Subject: REF BE/100/19/PL Eppinghoras

I have just returned to office following compassionate leave. I write to confirm that we are organising an ecological survey and providing updated tracking/visibility plans to satisfy the highways consultation (whereupon we will also clarify the land ownership query).

REV.	DESCRIPTION:	BY:	DATE:	PROJECT:	SCALE @A1:	DATE:
-	-	-	-	Land to the north of Springfields	1:50/100	09/08/19
				CLIENT:	PROJECT NUMBER:	DRAWING NUMBER:
				Mr C Thorne	0520-03	0520-03/03
				TITLE:	DRAWN BY:	CHECKED BY:
				Proposed Floorplans and Elevations - Plot 1	RL	CW
					REVISION:	-

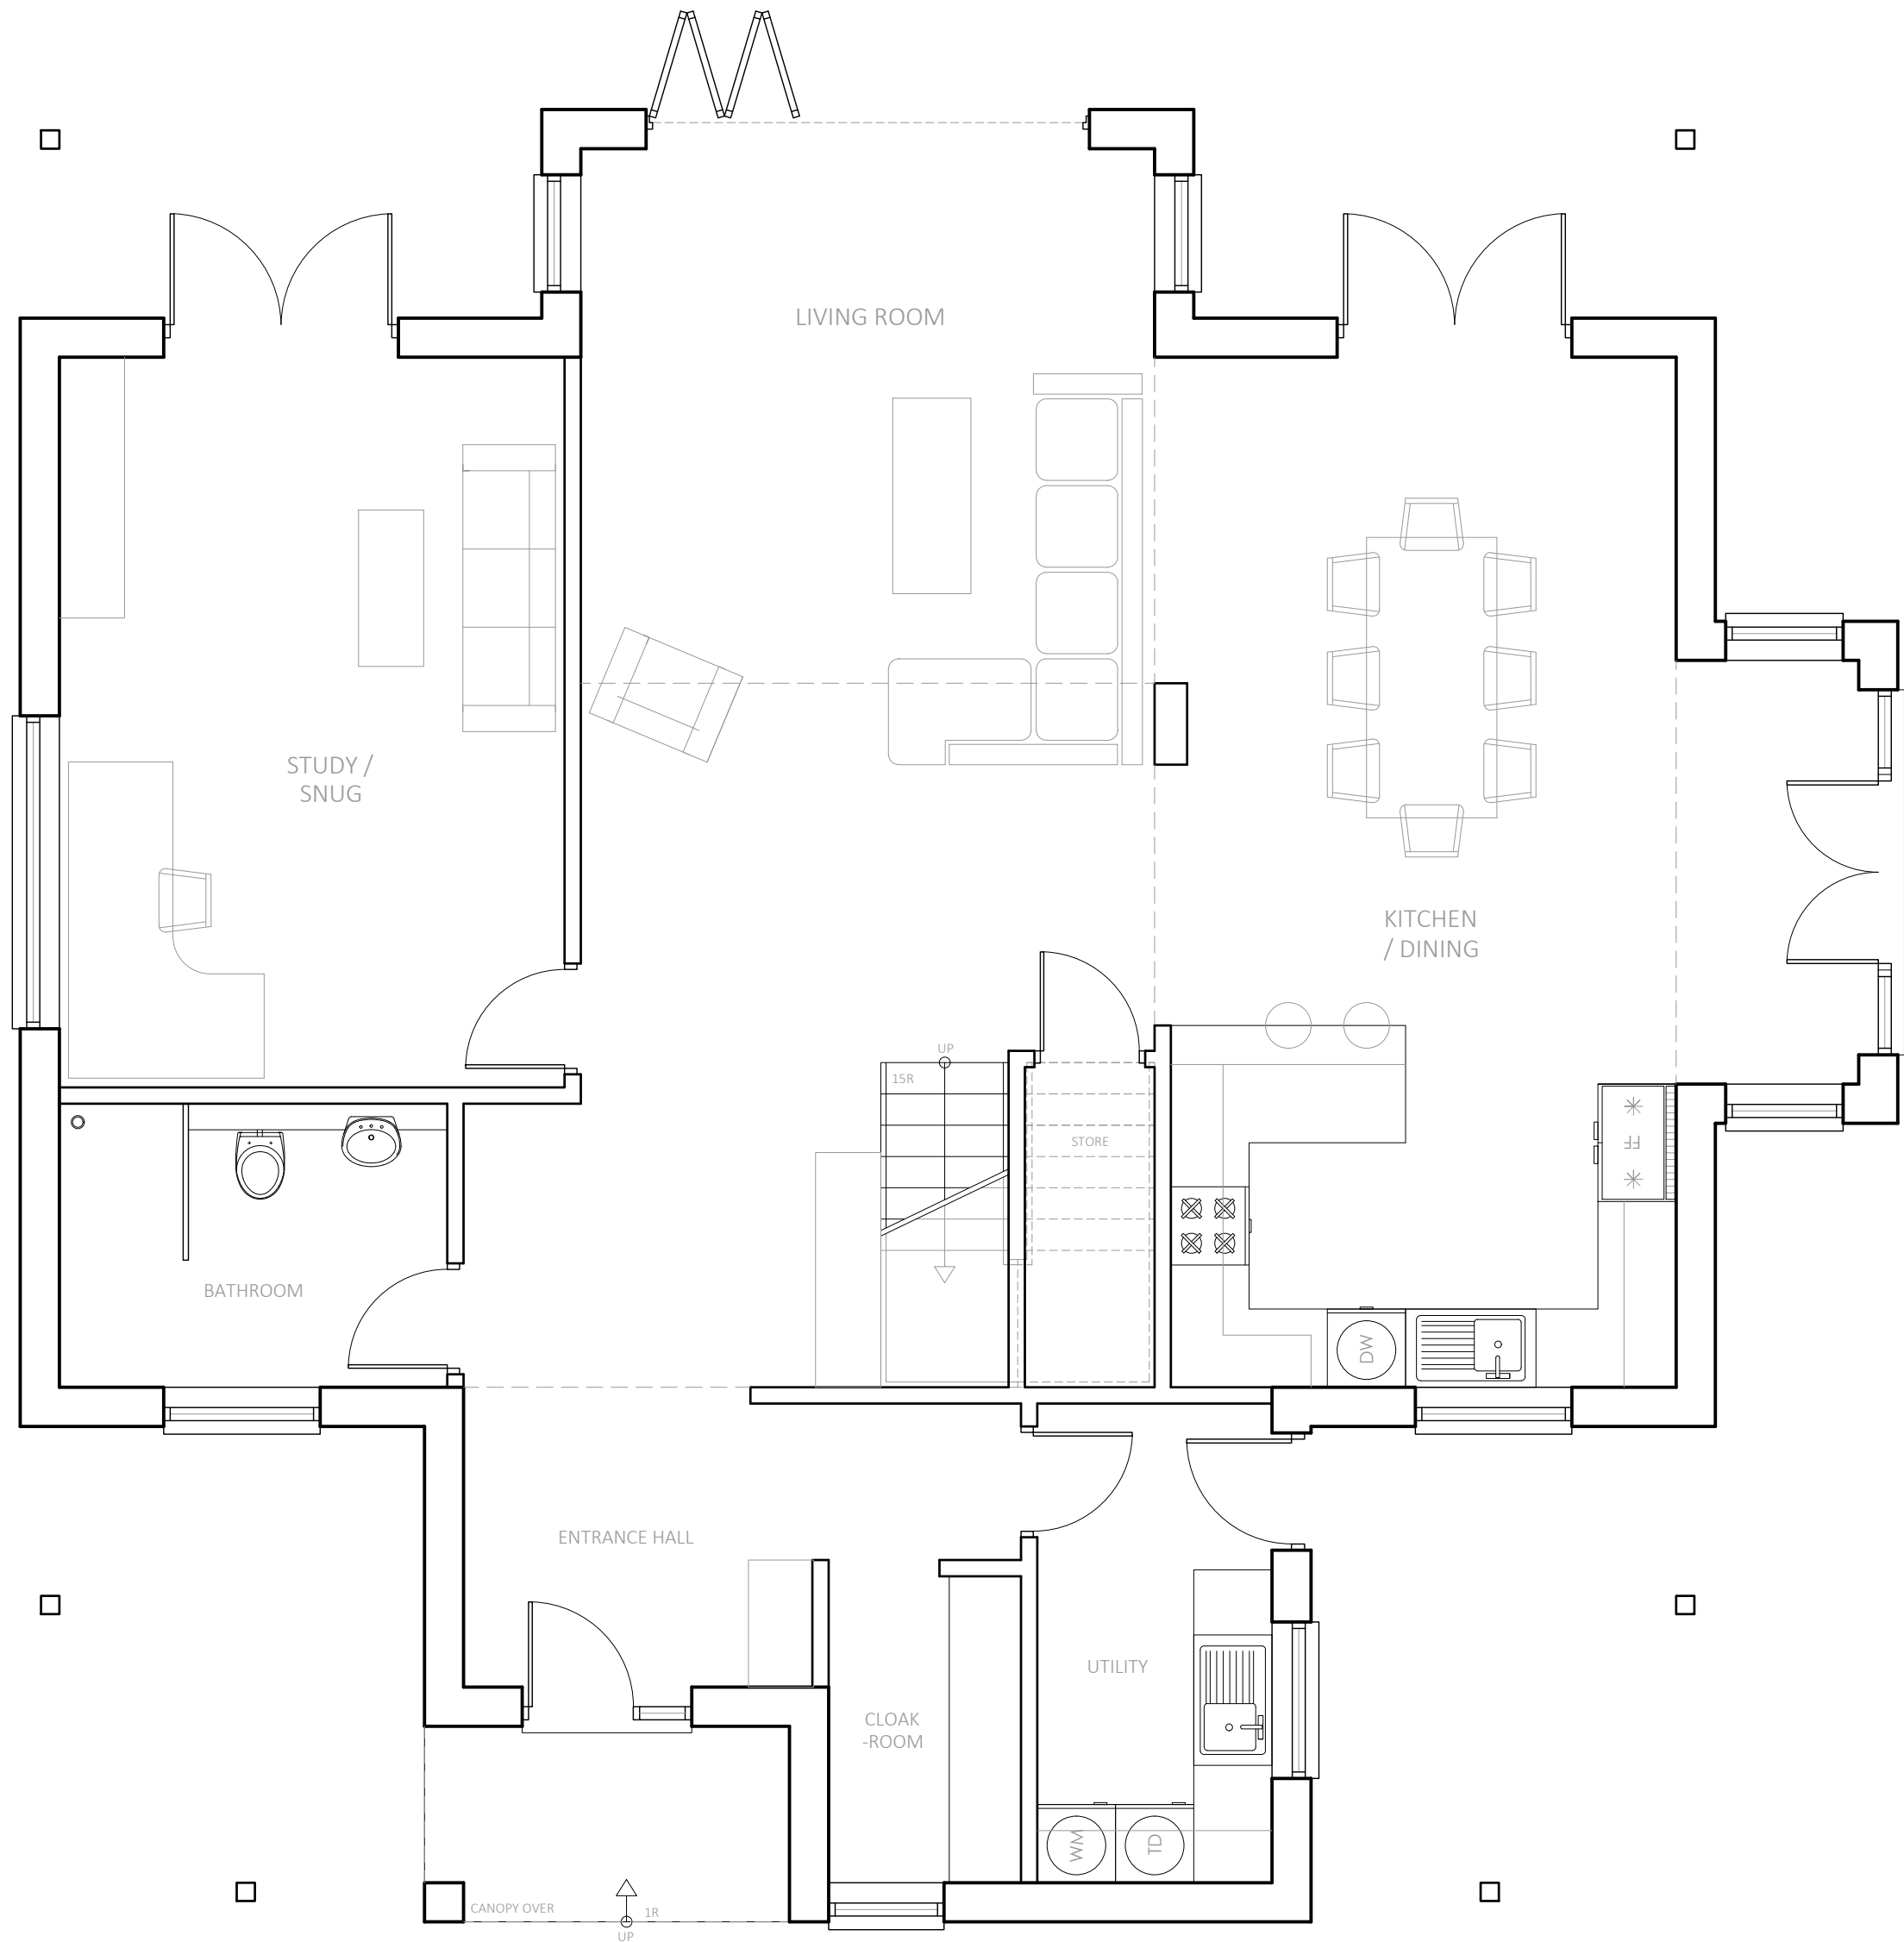
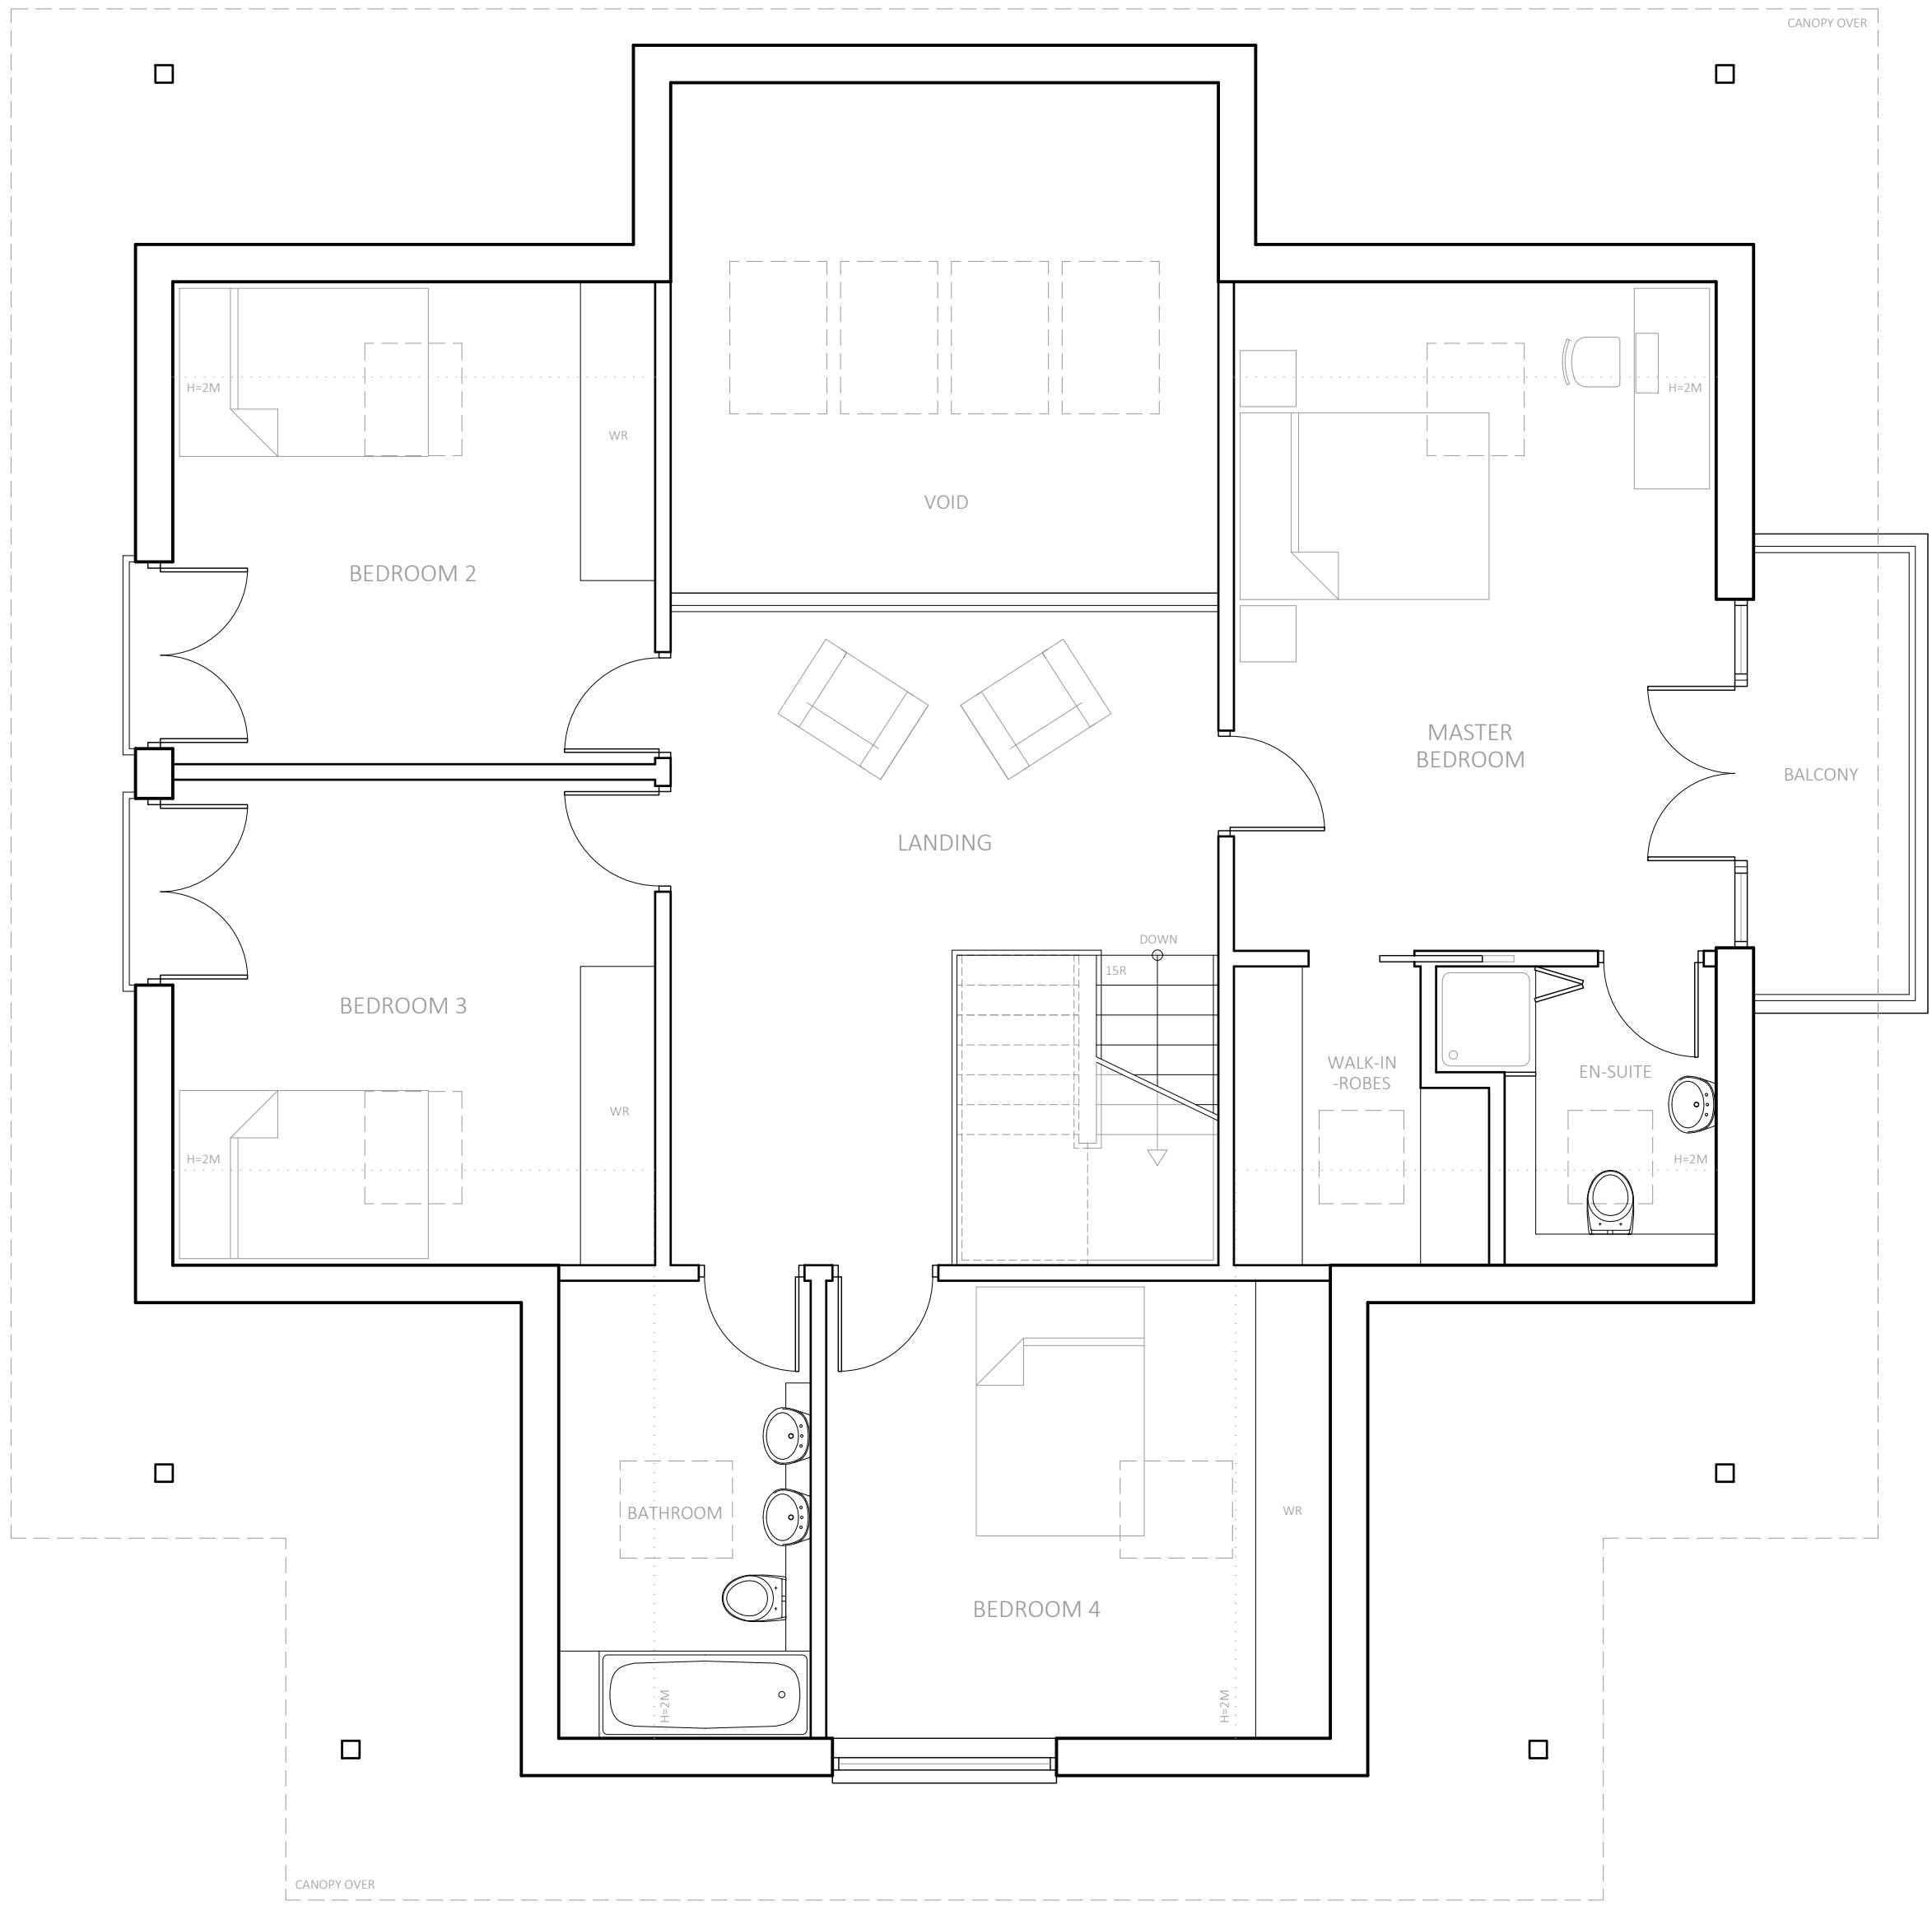
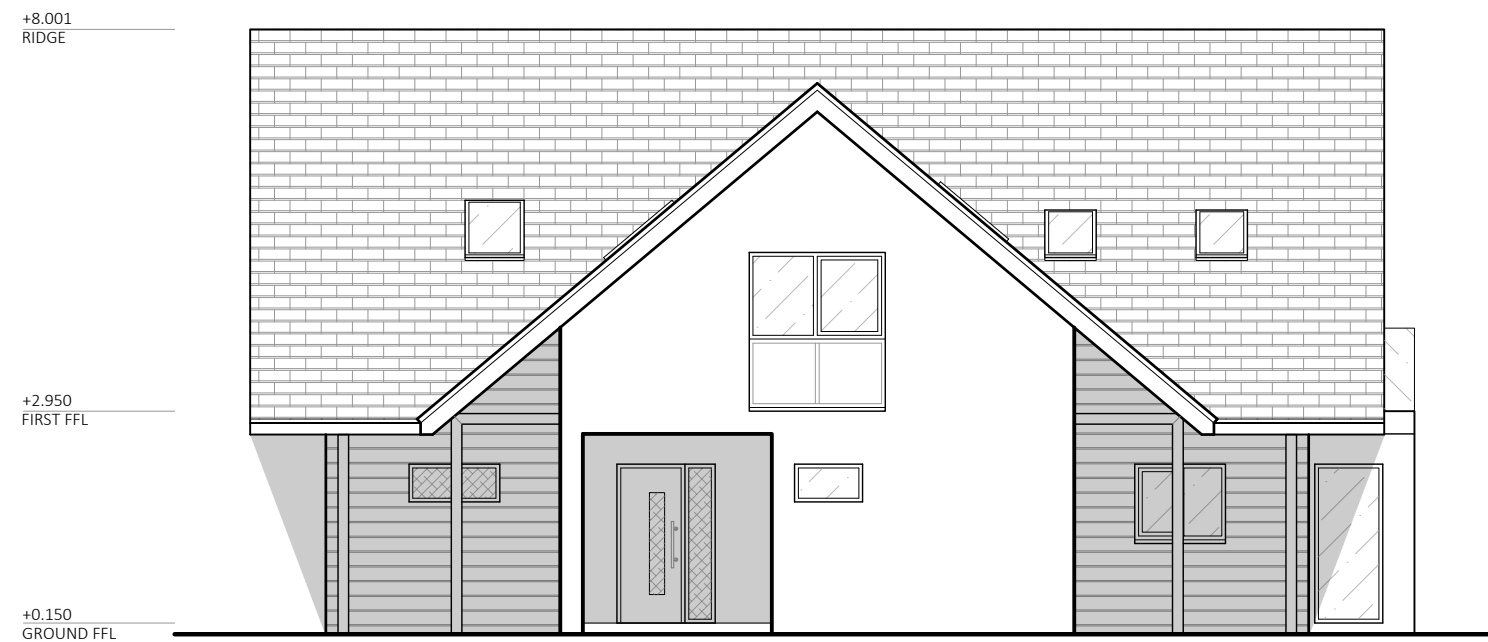
I also have some concerns with the proposed house designs in that the two pairs of Juliet balcony windows will allow overlooking of each other and also that the balcony on the south elevation to plot 1 will overlook the approved new dwelling. I note that there are limited windows on the rear east elevation (at FF) and wonder if more could be made of this elevation to avoid the overlooking from the flank FF windows.

I attach the ecological survey for the application. The recommendations with regards hedgerows have been adopted into a revised site layout plan, attached. We have also had consideration to your design comments, and issue updated floor plans and elevations.
